2 September 2020

**RE: RESPONSE TO SUBMISSIONS
DARLINGTON PUBLIC SCHOOL REDEVELOPMENT (SSD-9914)**

Tree management plan

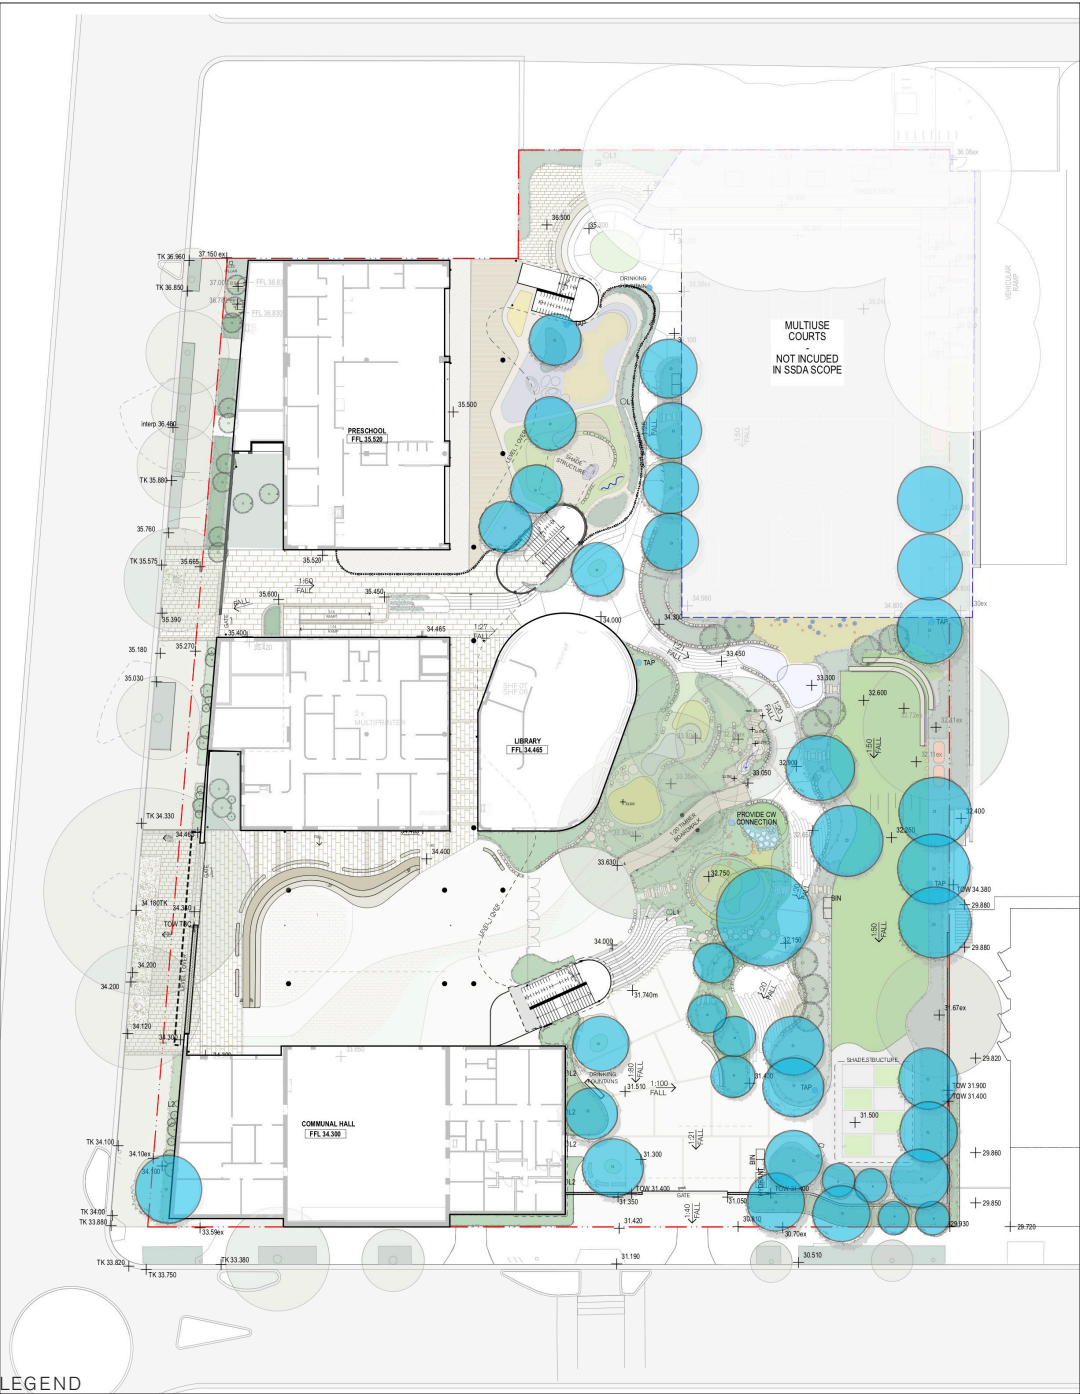
Clarify the number of trees to be removed and ensure reports consistently reference the correct extent of tree removal.

As described in the submitted EIS (Section 3.4, Section 5.9), the Landscape Tree Management Plan (Appendix J), and the Arborist Report (Appendix CC), 27 trees are proposed to be removed and 19 trees are proposed to be retained as part of the SSDA. These trees are as follows:

- Trees retained: 6, 12-15, 18, 56-68
- Trees removed: 1-5, 7-11, 16, 17, 19, 26-32, 47, 48, 50, 52-55

title
General Arrangement Plans
Upper Ground Plan - S2

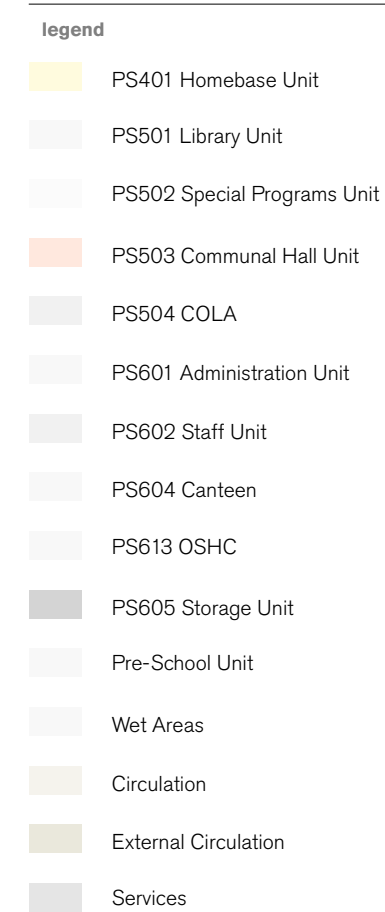
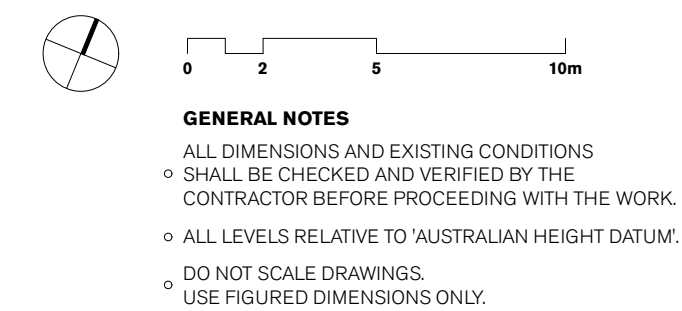
The description of the proposed pick-up and drop-off arrangement is inconsistent between the submitted EIS, Architectural Plans and Transport Impact Assessment. Clarify the proposed configuration.

An amended Upper Ground Level Plan is provided at **Attachment A** which correctly reflects this arrangement. The above description supersedes the description provided in the submitted EIS and Transport Impact Assessment.

Plan Comparison

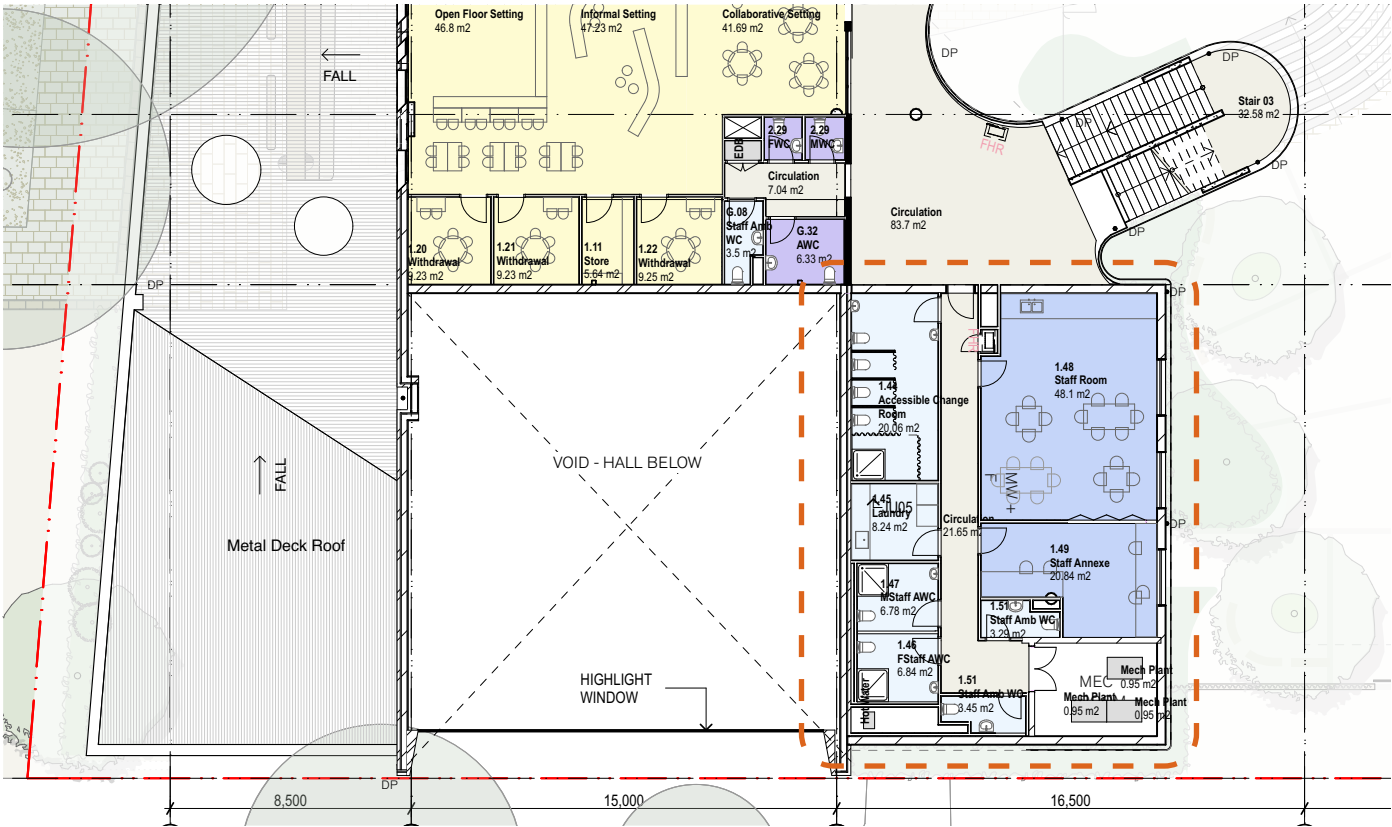
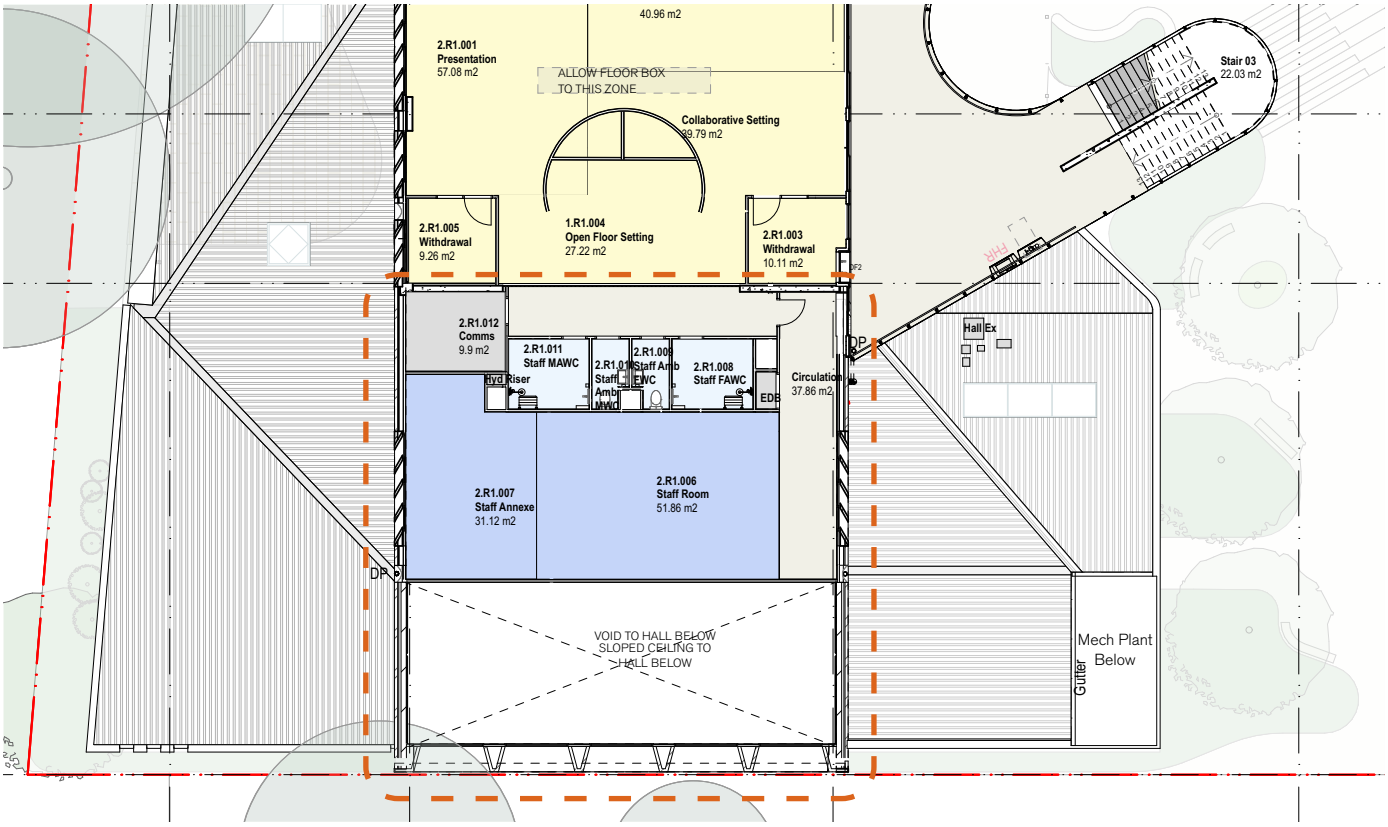
- Reduction in height of the southern-most sawtooth roof
- Articulation of the Southern Façade
- Reduction in bulk of the south-eastern wing
- Changes to the Level 1 western façade windows.

Lower Ground Floor Plan Comparisons

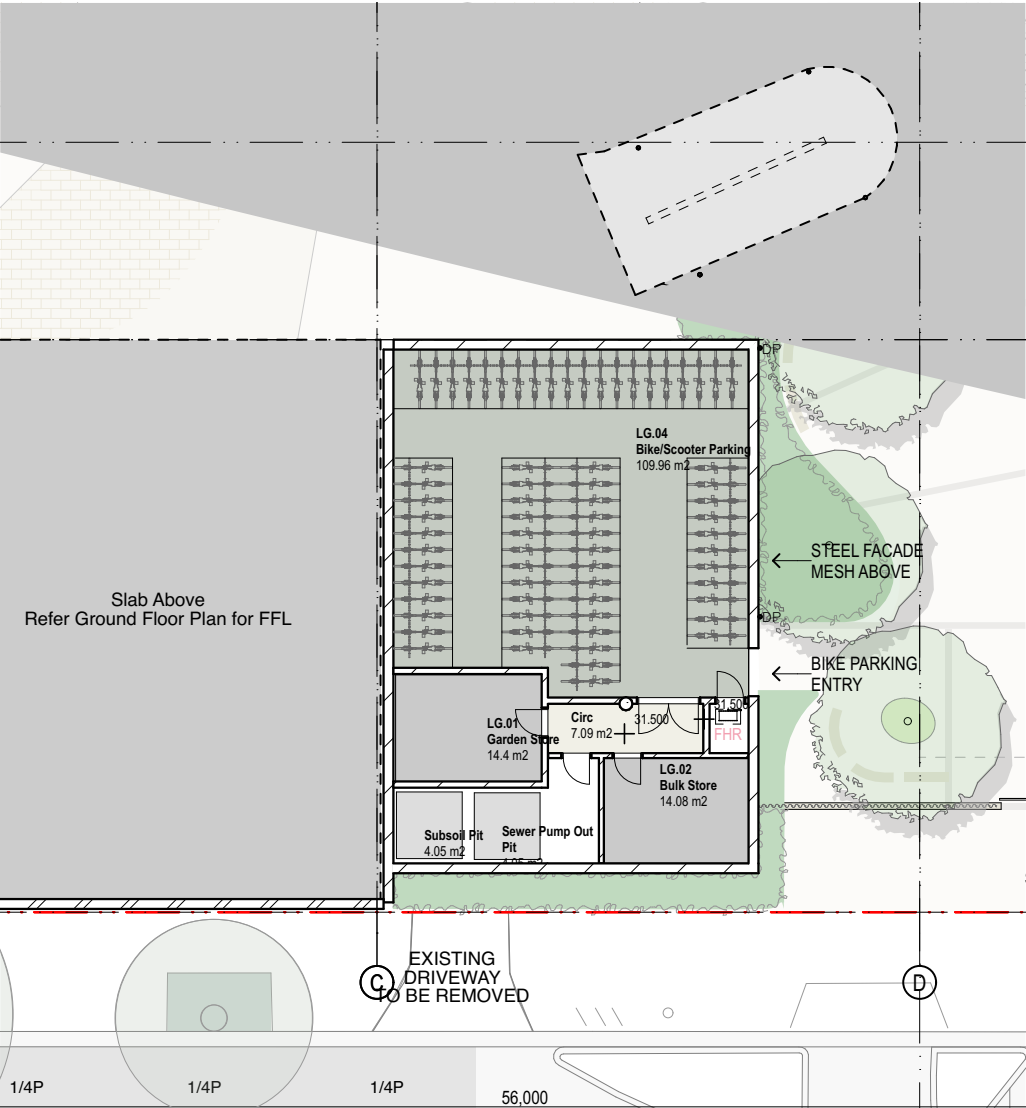
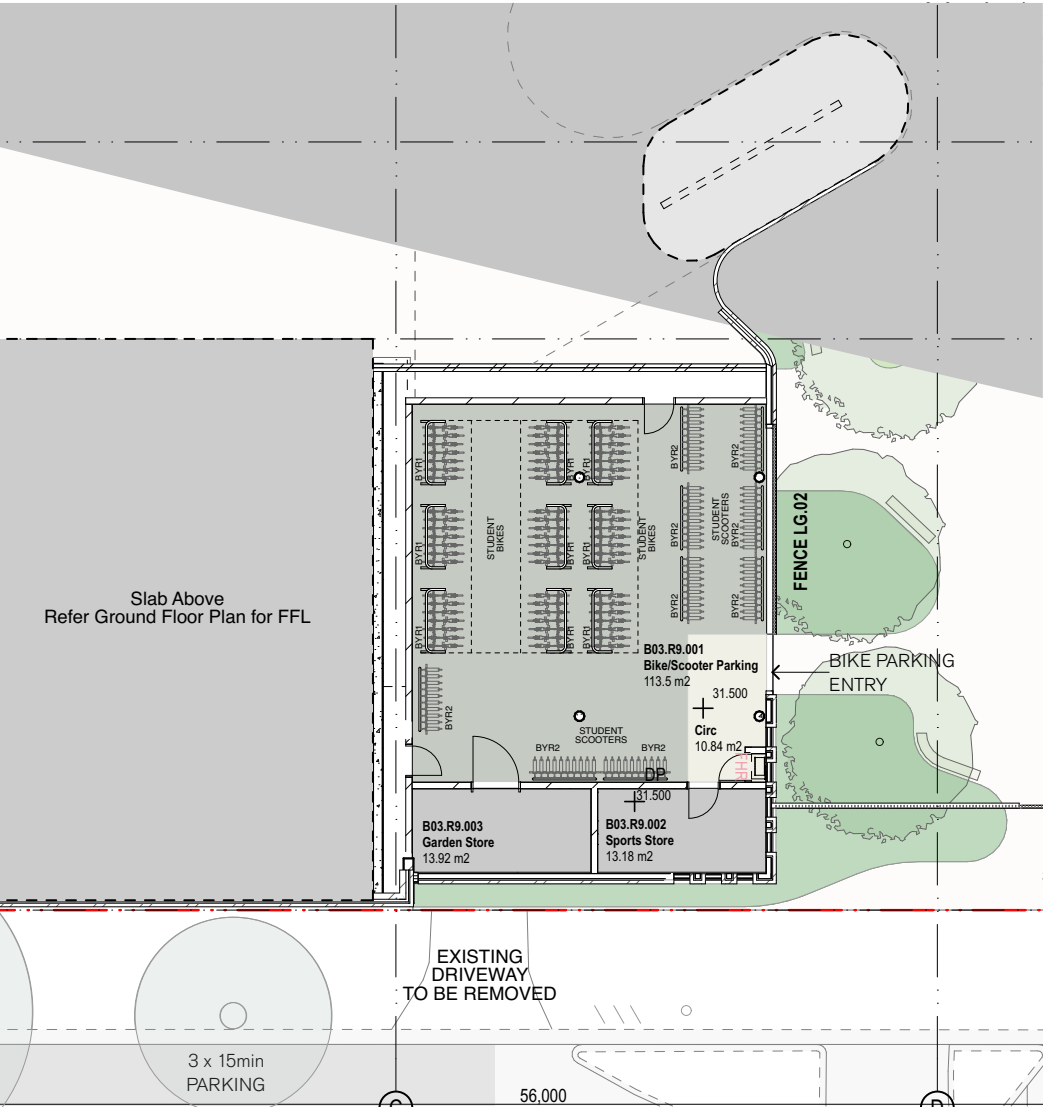
Insufficient bicycle and scooter parking provided for the expected future population of the school.

The amount of student bicycle and scooter parking has been increased from 67 spaces to 145 spaces. This is comprised of 63 bicycle parking spaces and 82 scooter spaces in a single, dedicated storage area adjacent to the Abercrombie Street entrance (**Figure 1**). This equates to 35% of the future student population of the school. Since the target mode share for the future student population is 35% of students riding/scootering to school, as outlined in the Green Travel Plan provided with the EIS (Section 9.0 of Appendix L), the increased provision is sufficient to accommodate the future population of the school, considering the target mode share.
